**Application by Mallard Pass Solar Farm Limited for an Order
Granting Development Consent for the Mallard Pass Solar Project
– project ref. EN010127**

Submission by Mallard Pass Action Group (MPAG)
– unique ID ref. 20036230

**Deadline 3:
Comments on Responses to ExA's First
Written Questions**

Drawing file: EN010127 / EN010127-000209-Figure 06.11_Green Infrastructure Strategy Plan.pdf

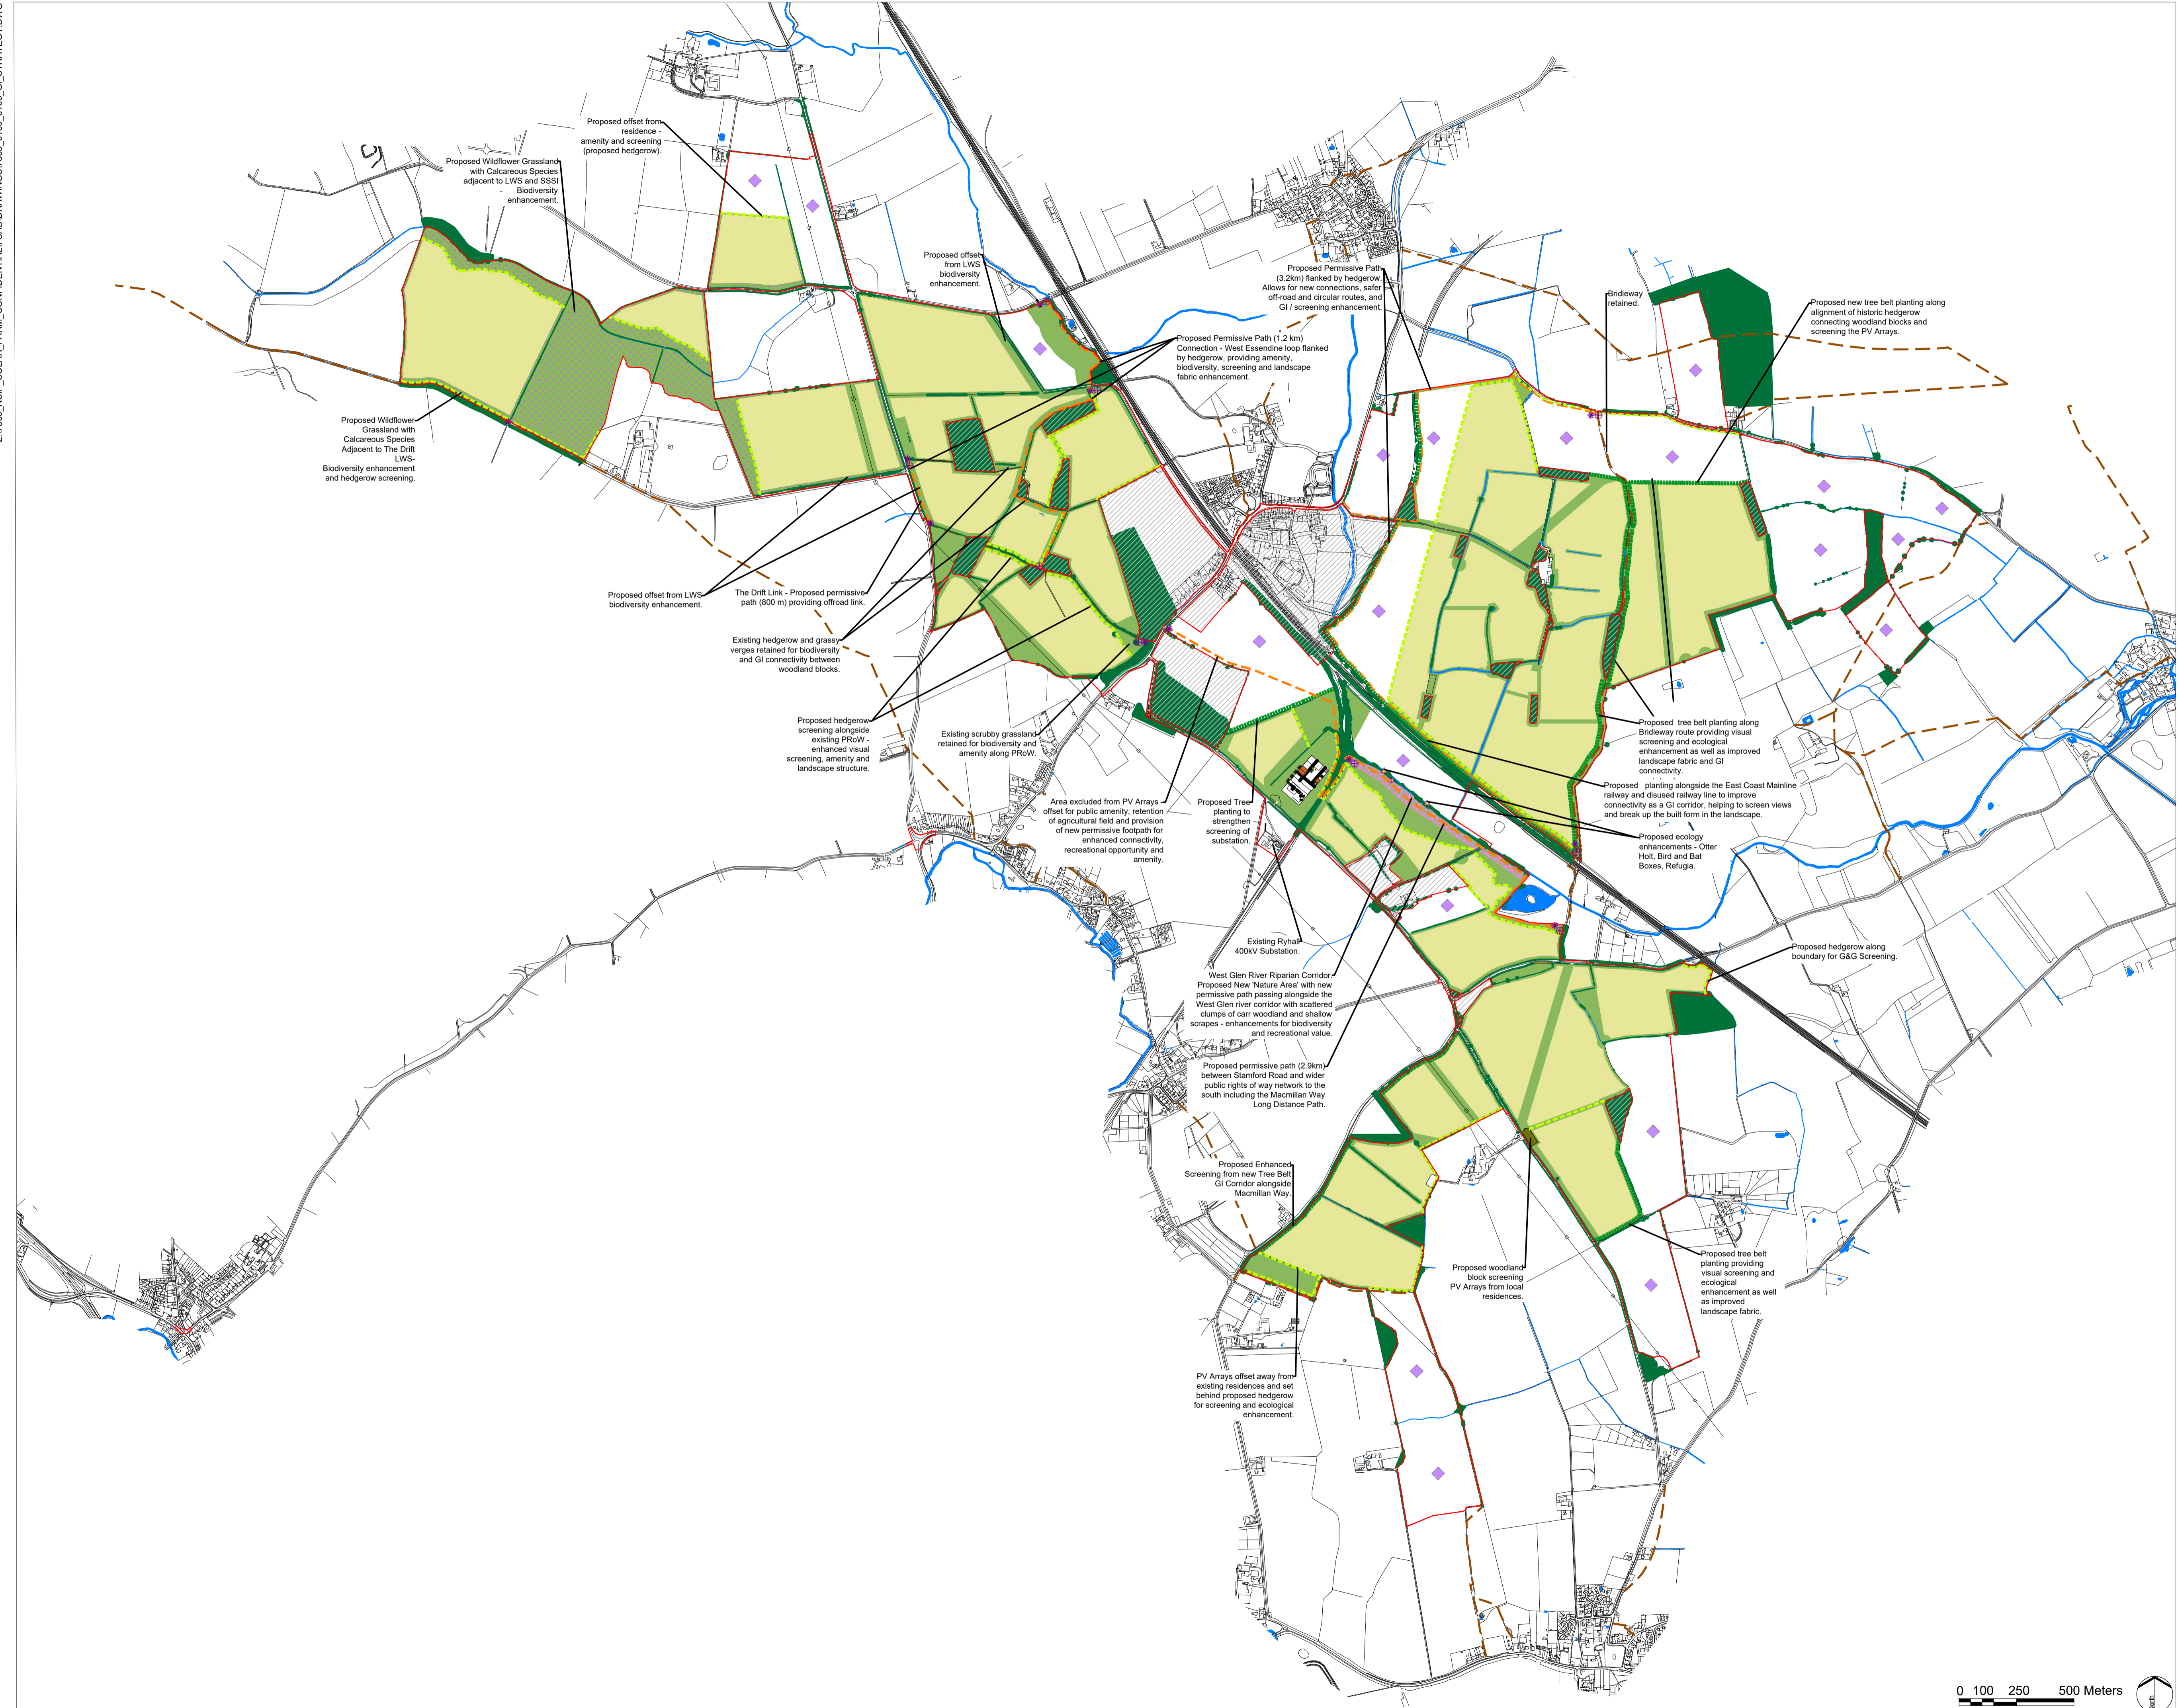
Given the majority of the woodland is encapsulated within the Order Limits but not part of the Order Limits, how can the Applicant promote talk about connectivity and wildlife corridors when they are not in control of all the rich ecological assets inside the Order Limit boundary? The existing landowners will have little interest in maintaining and promoting these isolated woodland areas, and may not even have access. It is critical that all ecological assets within or adjacent to the Order Limits are not compromised in any way and there is a joined-up plan for ongoing management.
